Recommendation Report for Planning Permission for Works or Extension to a Dwelling

REF NO: FG/152/21/HH

LOCATION: 1 Upper West Drive
Ferring
BN12 5RB

PROPOSAL: Proposed two storey side extension

Job Number: AR-123-B Drawing Number: 02 Revision: A

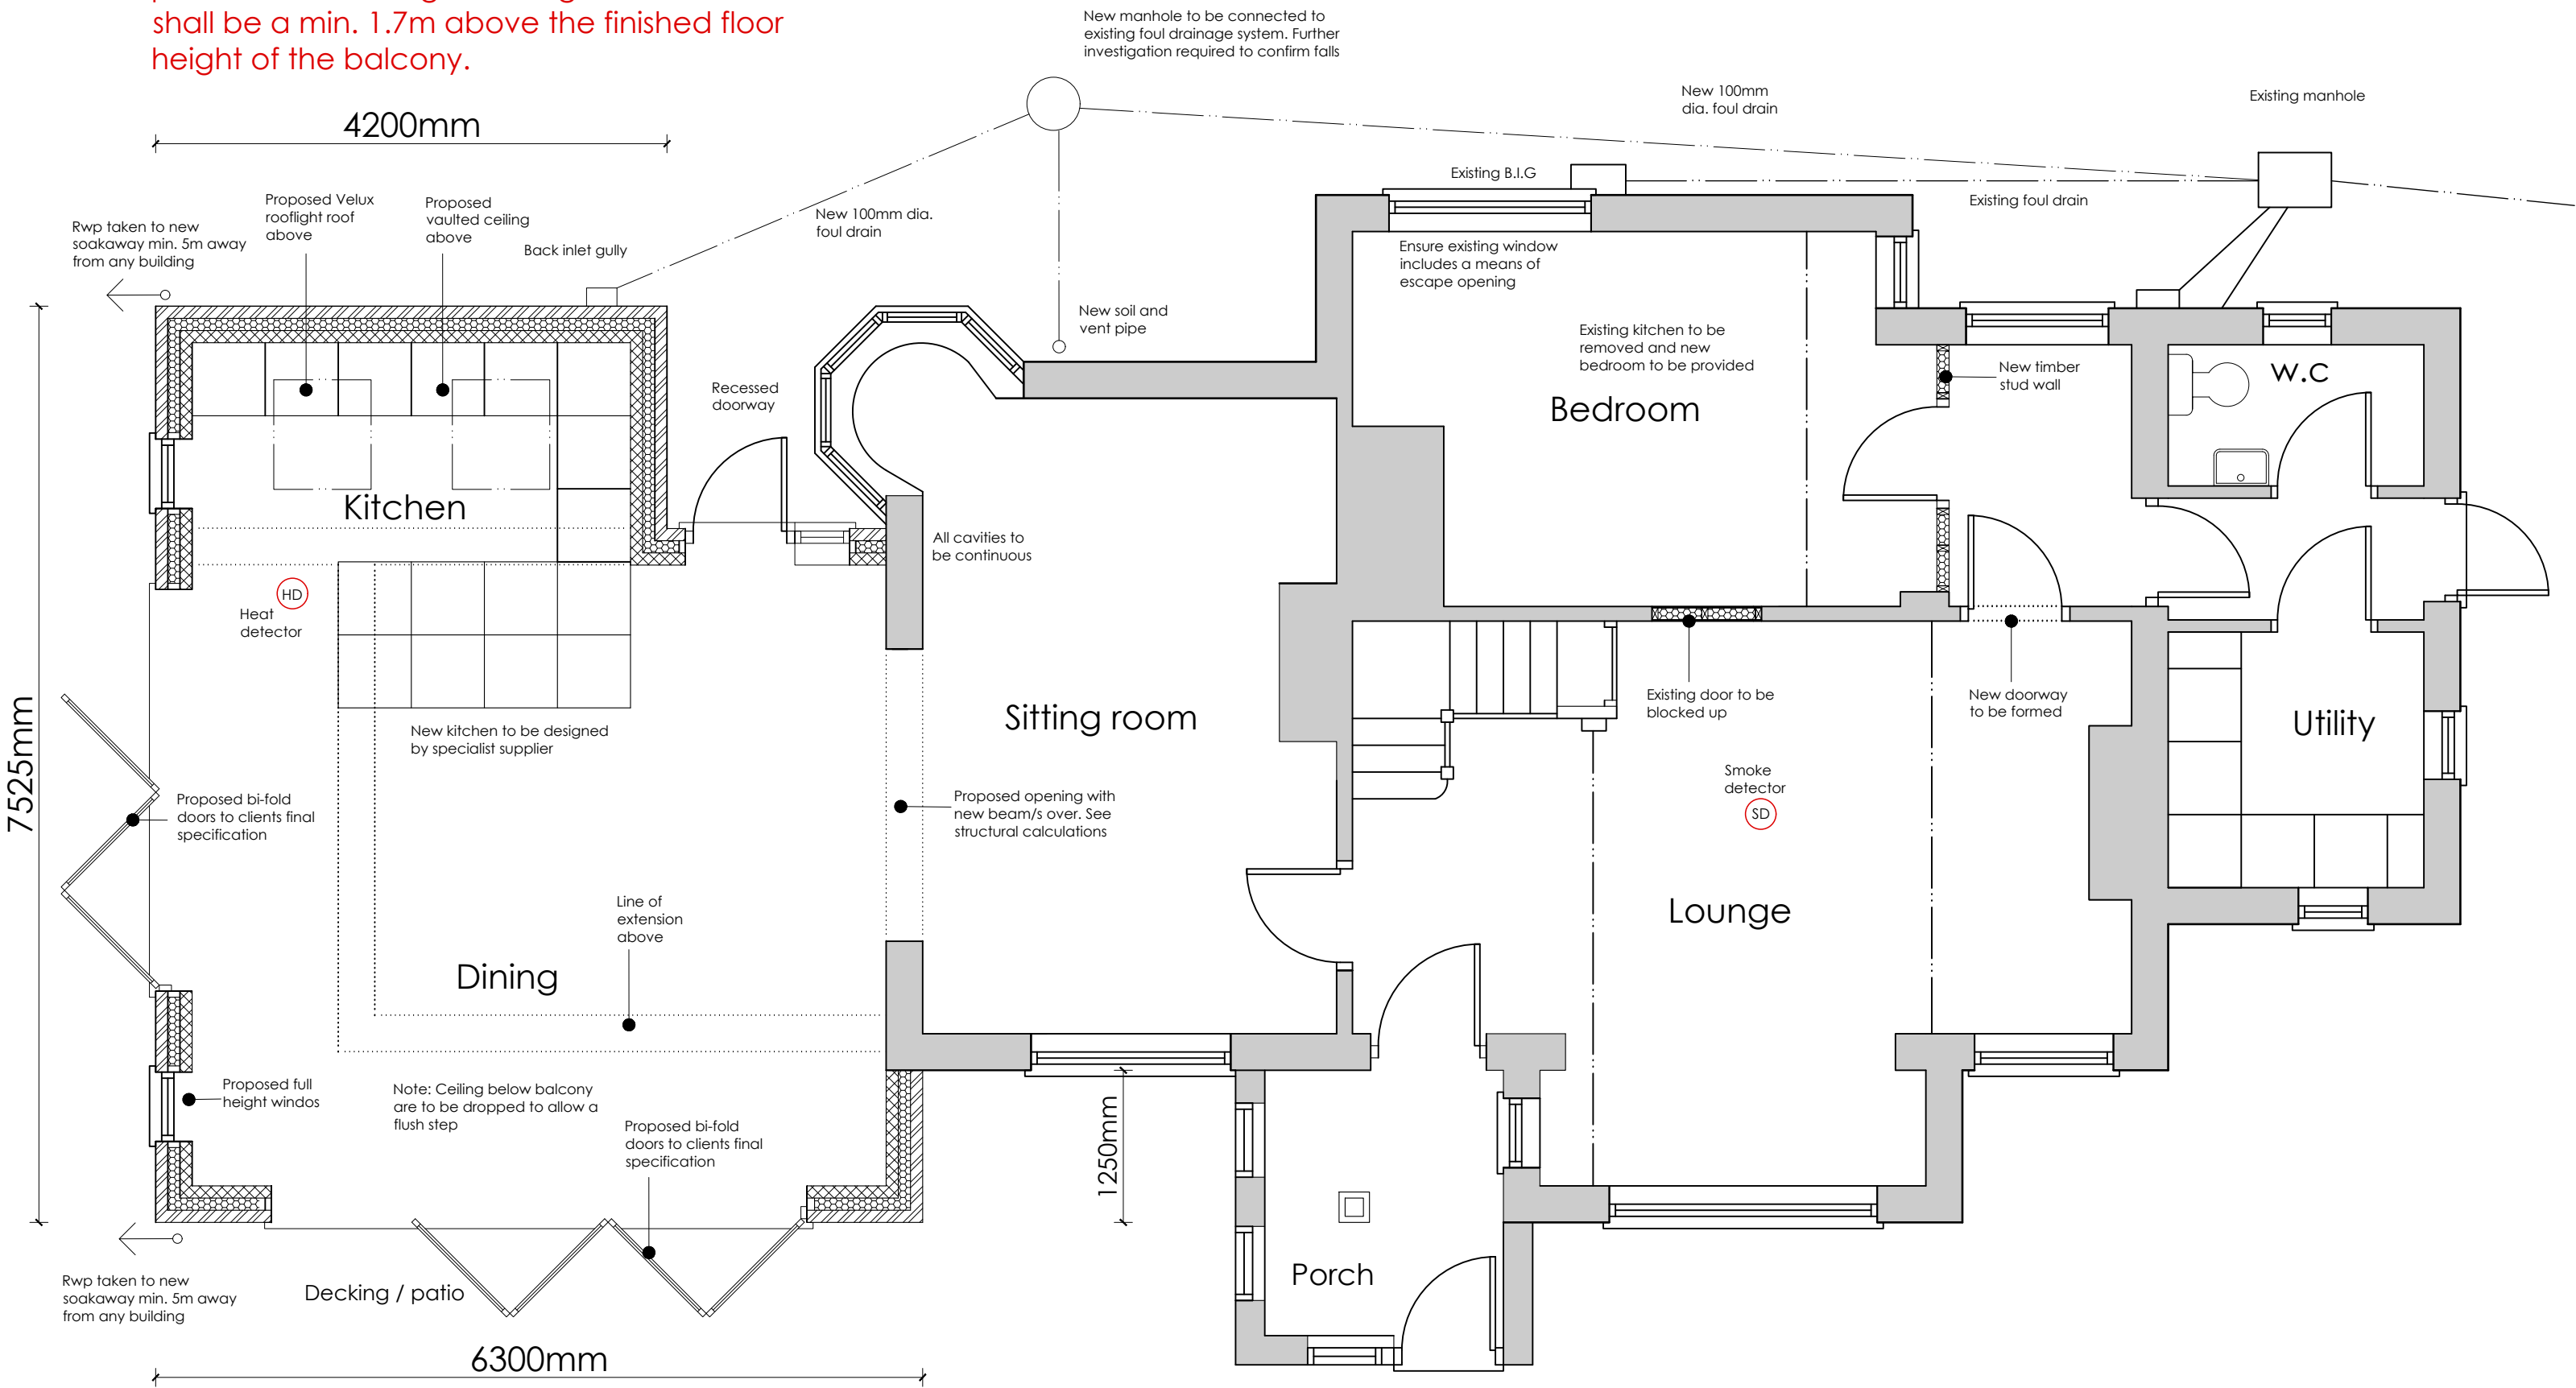
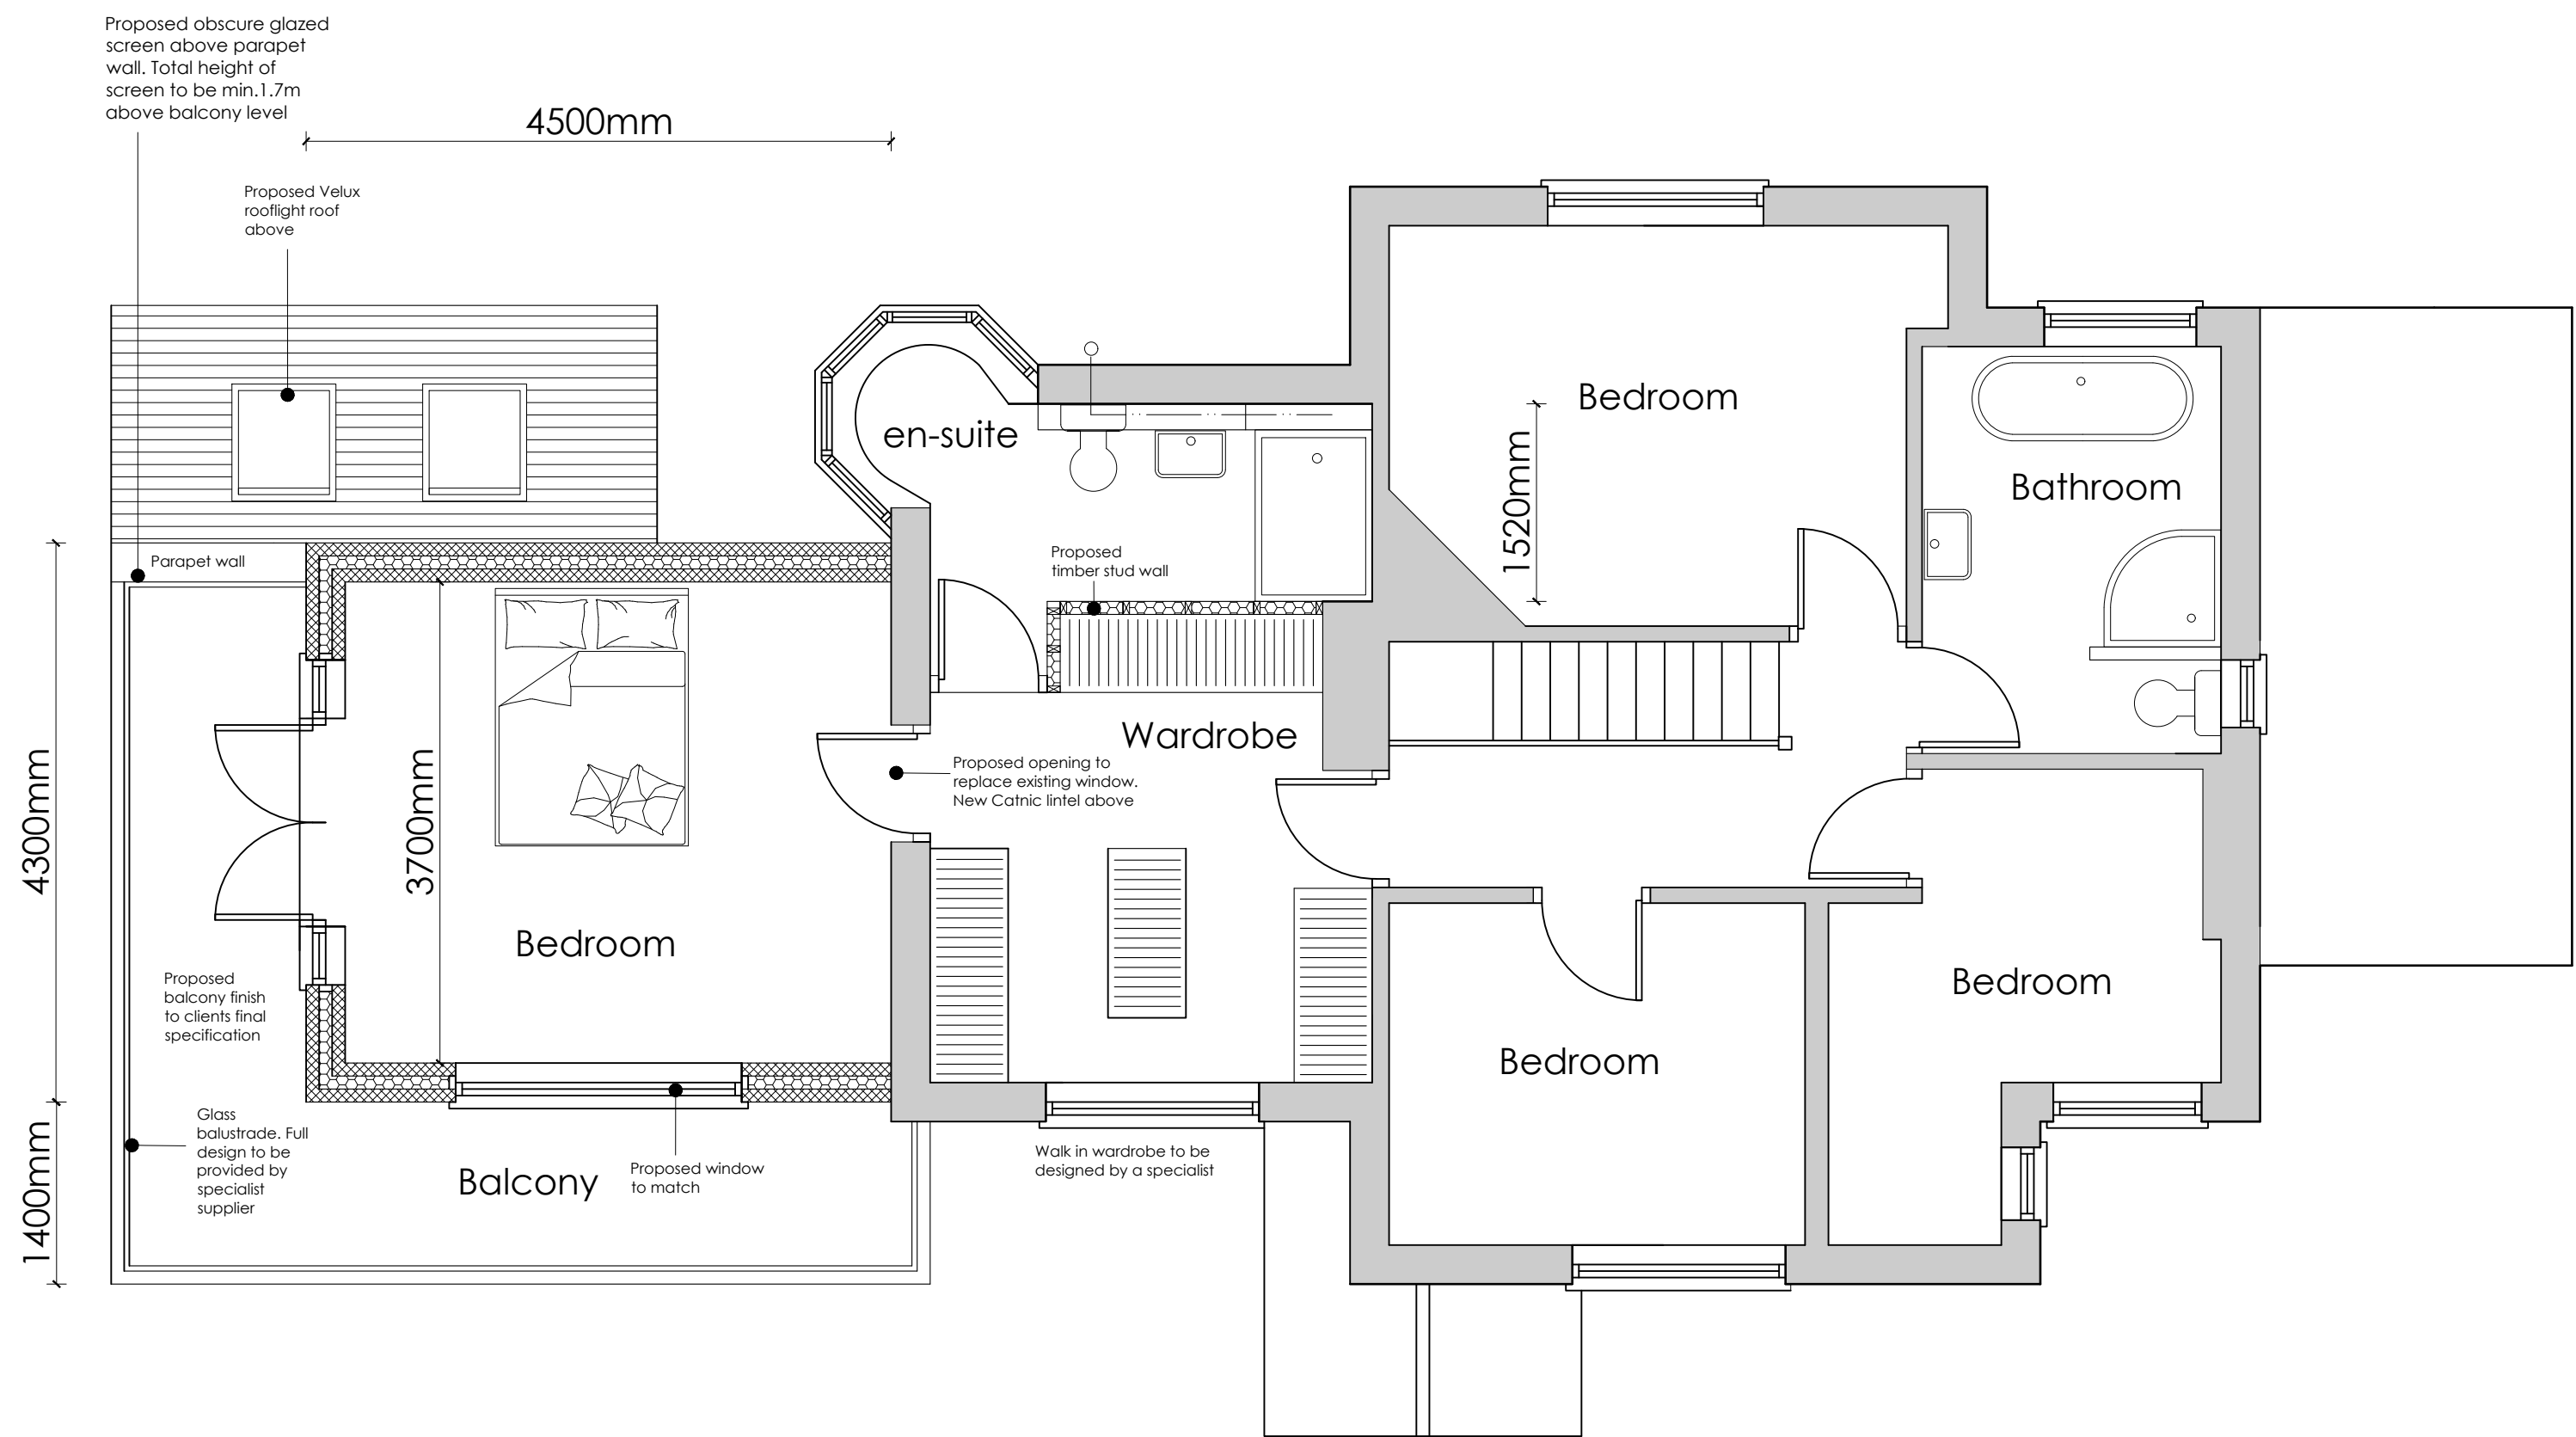
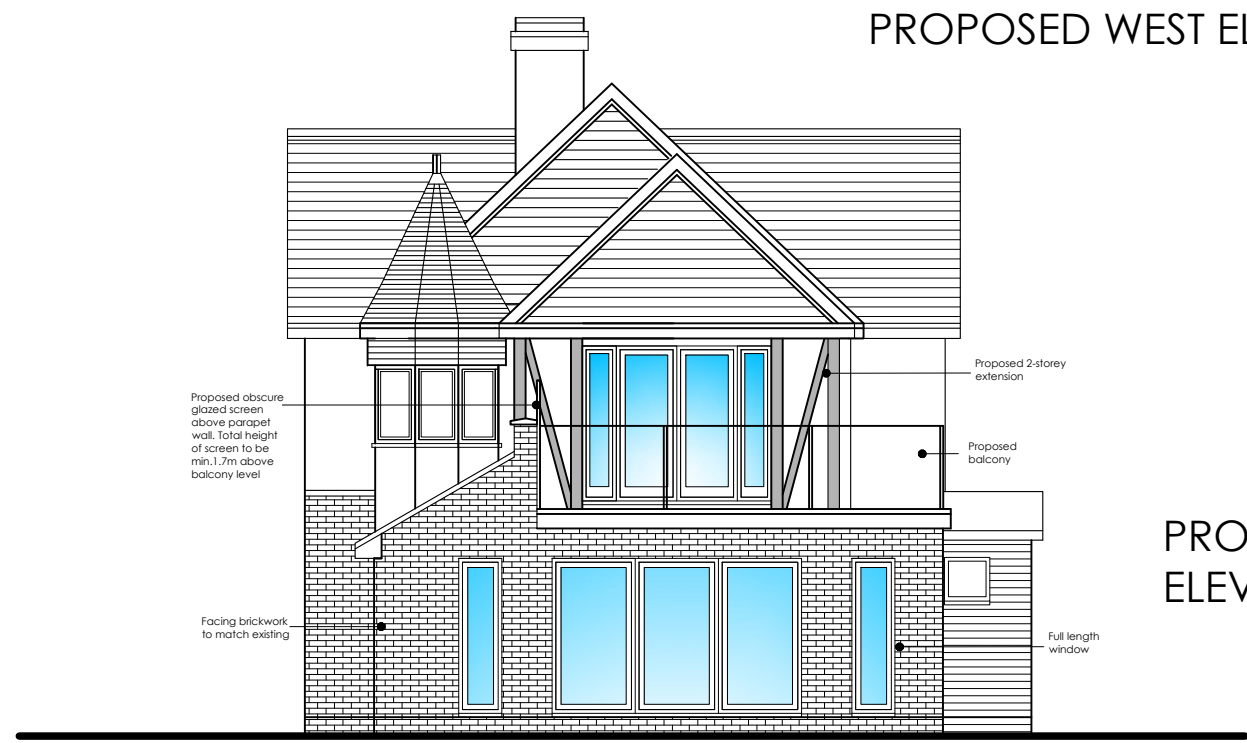
Due to around 2.20m retained to the rear (west) boundary there is increased risk to overshadowing or overbearing effects to neighbouring property number 1 Ferringham Way to west. However a gap of around 3.51m remaining to neighbouring property reduces impact of overshadowing. Also due to the design of the proposals at first floor being narrower footprint than at ground floor there is further distance to neighbouring property at first floor so is acceptable.

A 1.7m high obscured screen will be conditioned to be constructed to the first floor balcony to west parapet wall to prevent adverse overlooking effects to neighbouring property number 1 to west.
